**From:** Amanda Scholes on behalf of Planning.Responses  
**Sent:** 11 June 2020 09:11  
**To:** Planning Scanning  
**Subject:** FW: Planning Consultation on F/9/20/DOC  
**Attachments:** Ag Invest - Wicks Farm - ADC - SuDS - Discharge of Conditions - 30th March 2020.pdf; Ag Invest - Wicks Farm - ADC - Reservoir Design - 9th June 2020.pdf; Ag Invest - Wicks Farm - ADC - Polytunnels - CEP - Flood Risk Assess - 17th January 2019.pdf; Ag Invest - Wicks Farm - ADC - Polytunnels - CEP - Flood Risk Assess - App 1 - 17th January 2019.pdf; Ag Invest - Wicks Farm - ADC - Polytunnels - CEP - Flood Risk Assess - App 2 - 17th January 2019.pdf

**APPLICATION NO:** F/9/20/DOC

**Site Address:** Wicks Farm Ford Lane Ford BN18 0DF

**Description of Works:** Approval of details reserved by condition imposed under ref F/30/18/PL relating to Condition No 3 - surface water drainage.

TYPICAL SECTION SHOWING SWALE 1 PROFILE

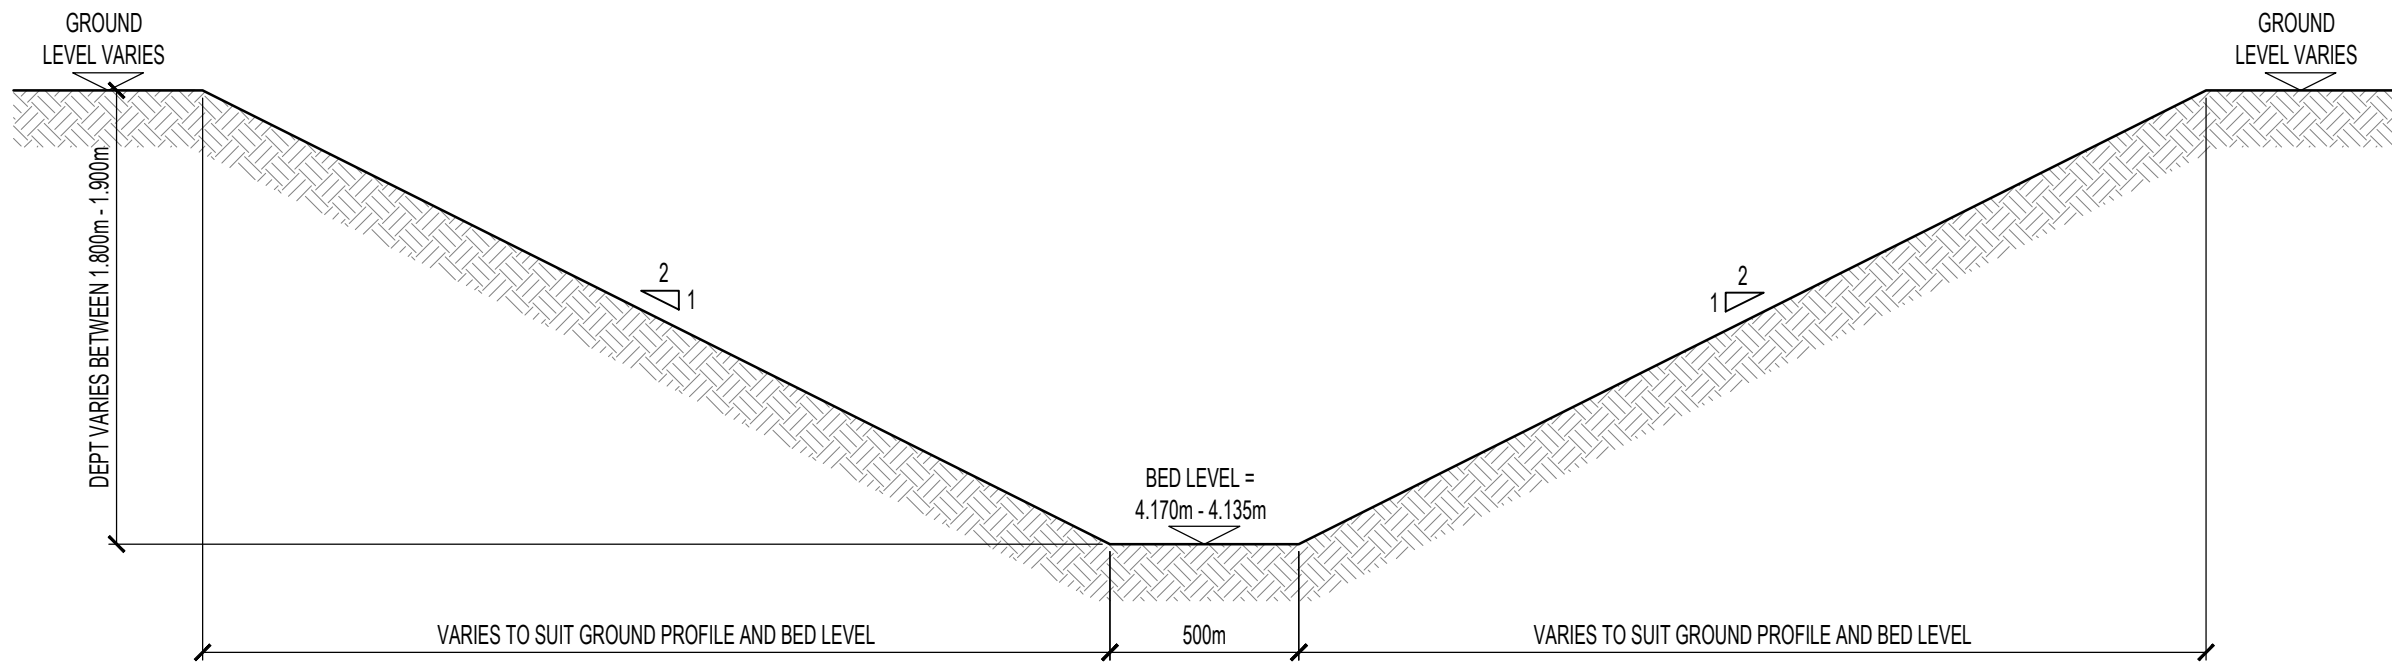
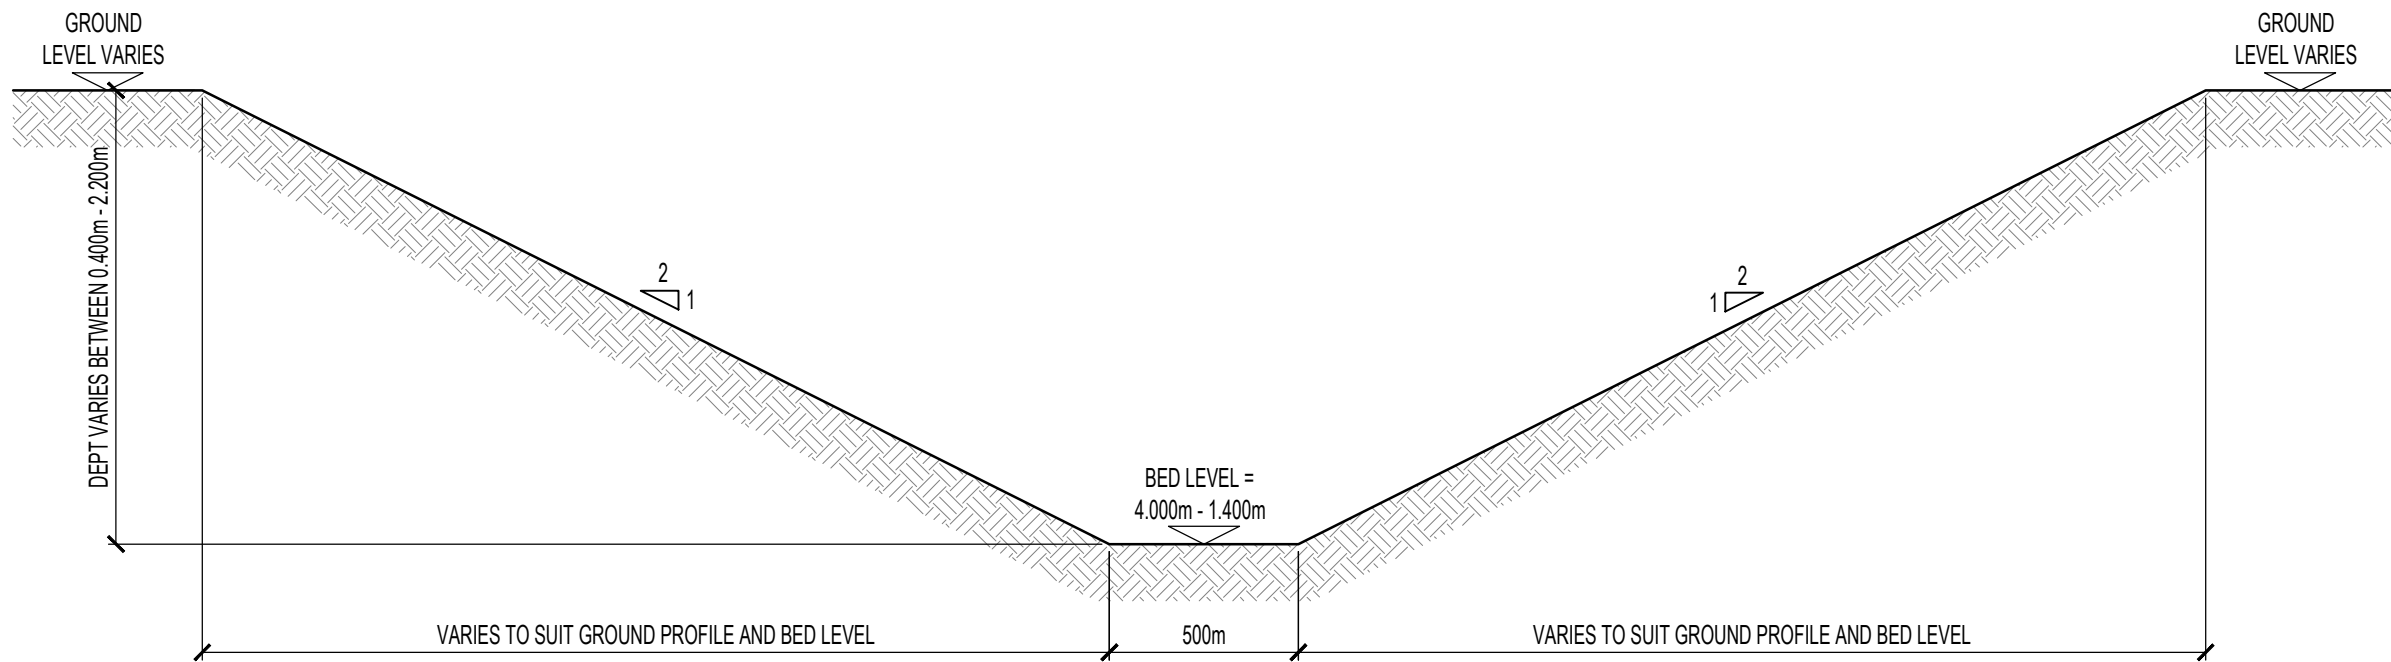
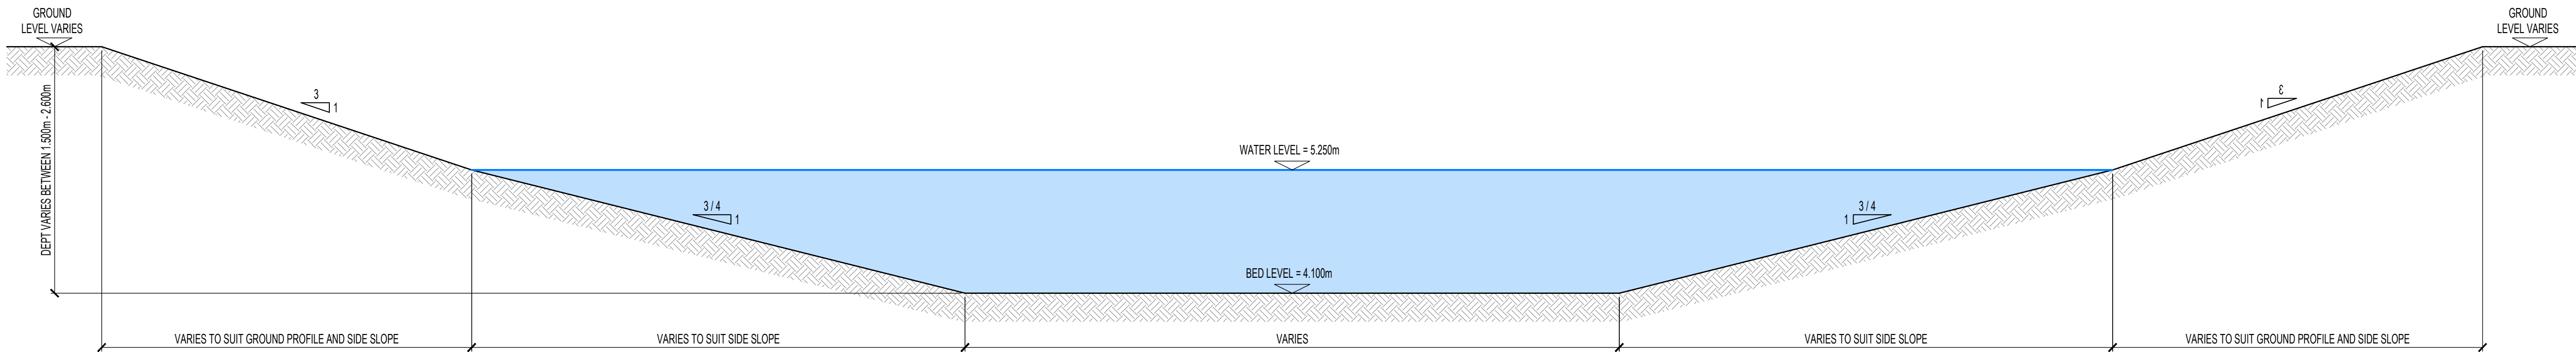
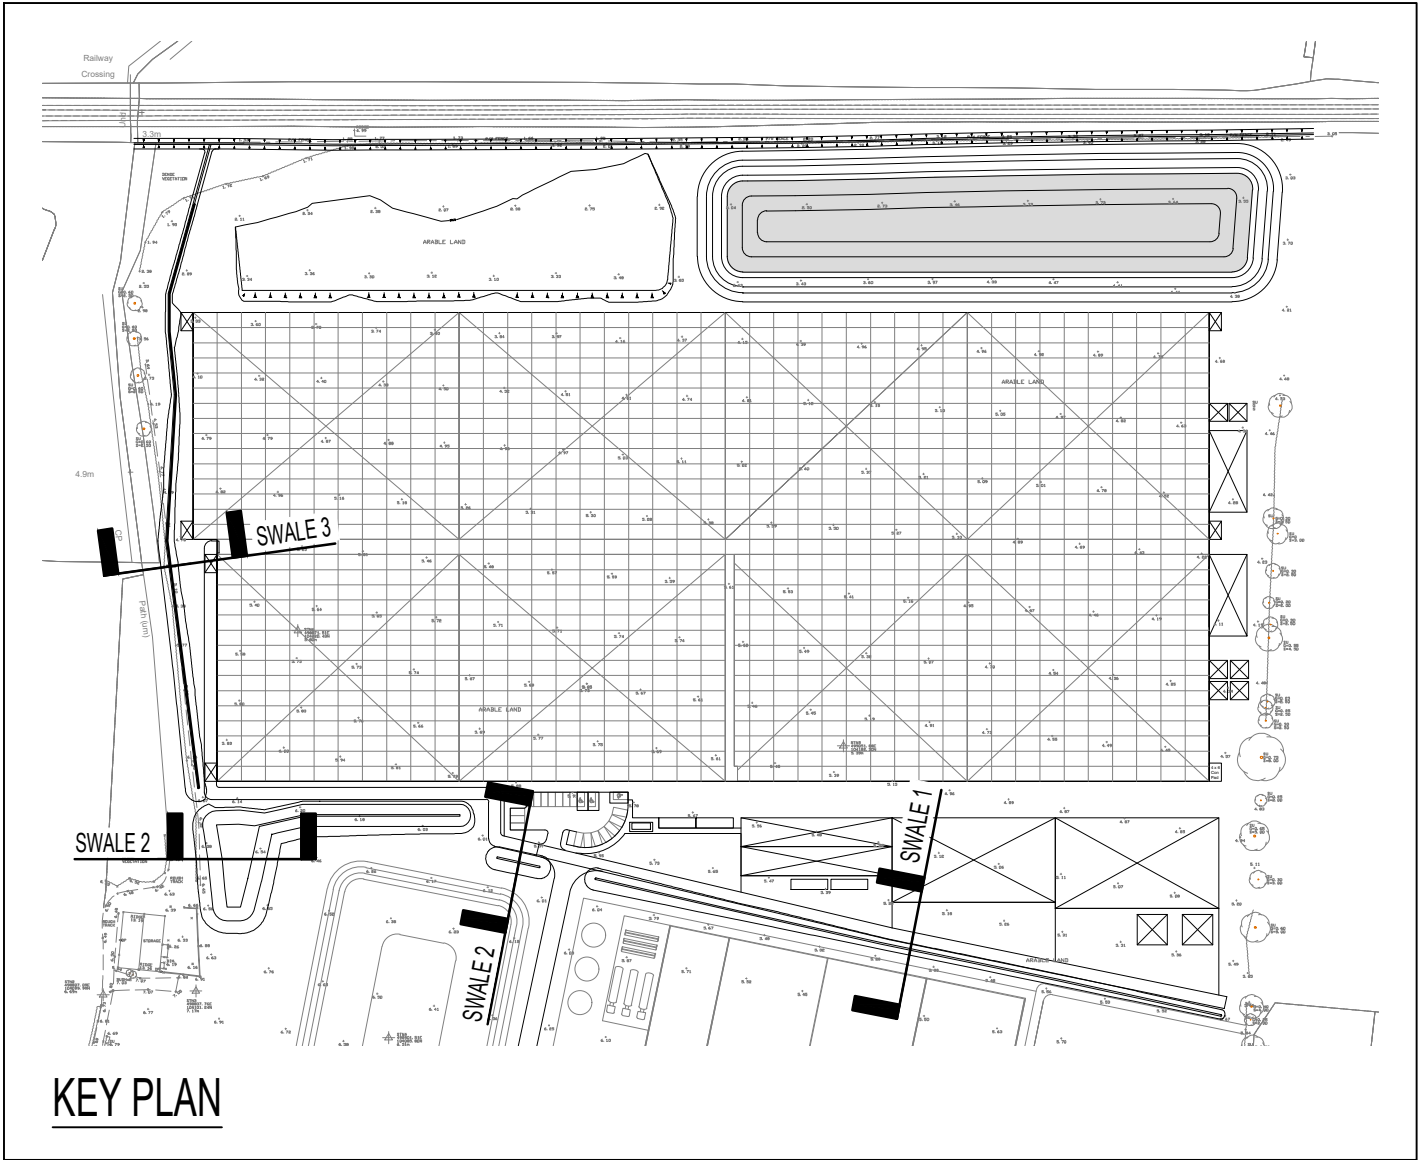
14. Swale connection to the new northern ditch – angle the point of entry to ensure flows merge in an improved manner.
15. Provide fully detailed insitu headwall construction details, for links between pond 1 and swale, and between swale 1 and 2.

16. Incoming 225mm pipe to swale 2 – provide min. 100mm freeboard between swale bed and pipe invert.
17. Pipe concrete bed and surround detail – specify the specific concrete mix on the detail itself.

21. Outlets to swale 1 – provide min. 100mm freeboard between swale bed and pipe inverts.
22. Provide positive fall on pond 1 (swale) bed.
23. All pipes to connect soffit to soffit unless otherwise specified – add note.

25. Pond 1 system – provide pipe network numbered plan to support causeway flow calculations.
26. Pond 1 and associated swales – show top of bank levels on all sides.
27. Provide causeway flow calculations for reservoir system. The CEP calculations provided were only preliminary and do not reflect the actual design.
28. Maintenance manual - to be a separate document. Needs to explain how each system is designed to work and specify who will be responsible for maintaining the system after construction. The manual provided is quite generic and not really site specific – please adjust as necessary. There needs to be a focus on catchpits, hydrobrakes, headwalls (grilles), perforated pipes, reservoir, ditch, etc maintenance.

PRIVATE MANHOLE DETAIL TYPE W (WITH CATCHPIT)
DEPTH FROM COVER LEVEL TO SOFFIT OF PIPE 1.0m - 1.5m
INTERNAL CHAMBER DIAMETER 1500mm*
MAX. SEWER DIAMETER 375mm
(SCALE 1:25)

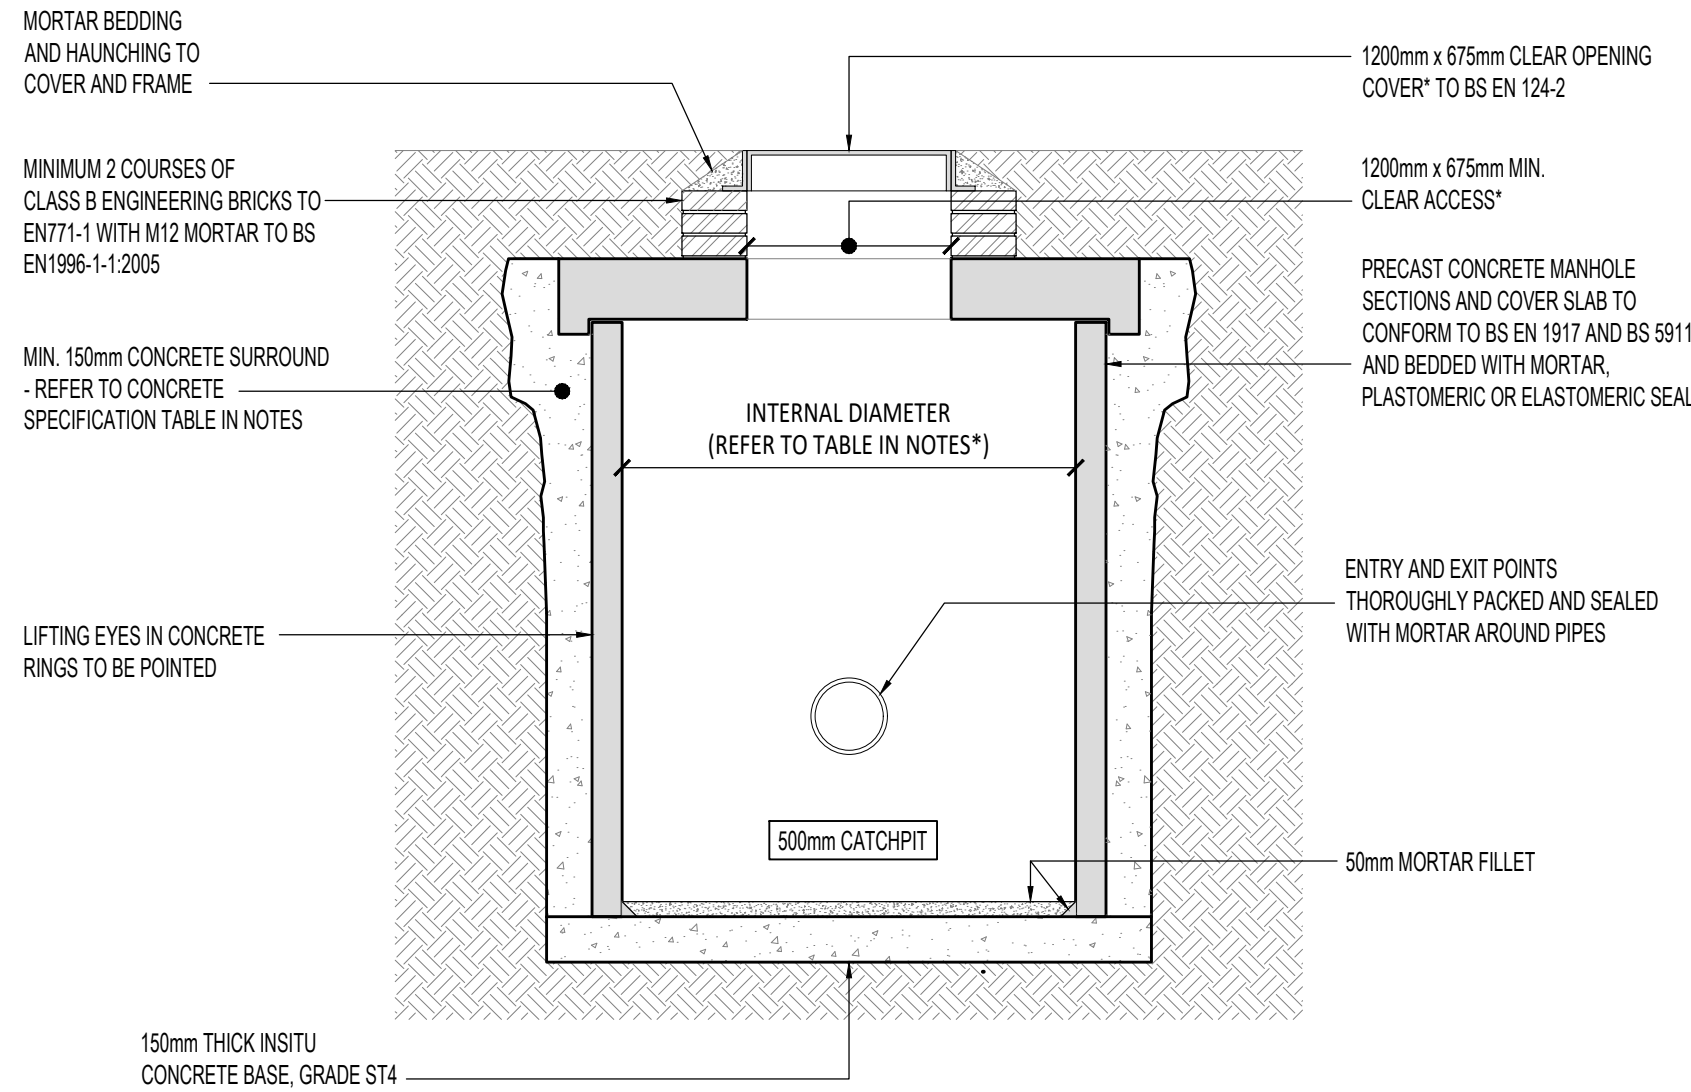
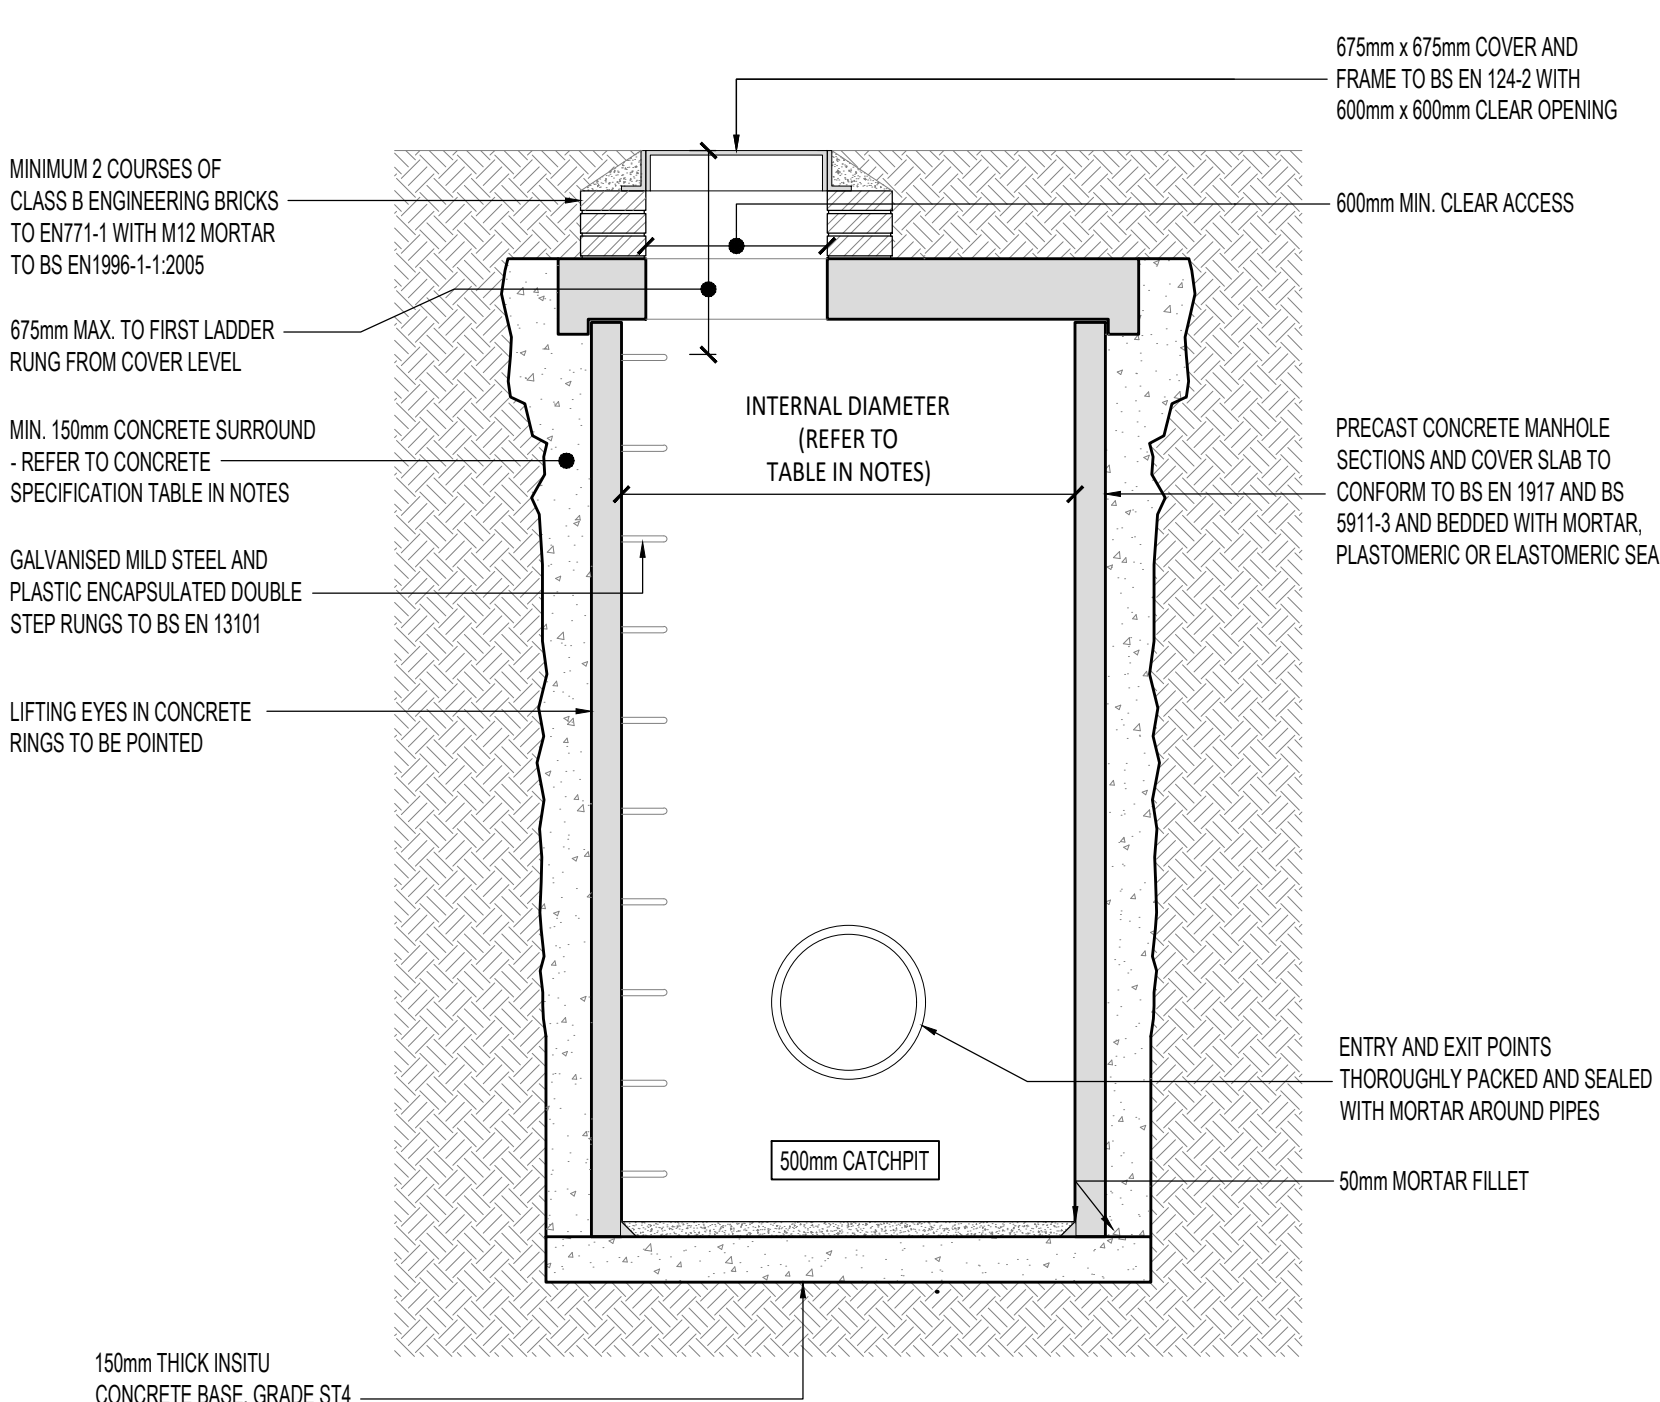
12. Catchpit type W detail – include step rungs for access.
13. Reservoir outlet is at very steep gradient and connecting at 90 degrees to the hydrobrake. Resultant flows could affect the performance of the hydrobrake – could this arrangement be revised to improve the situation.
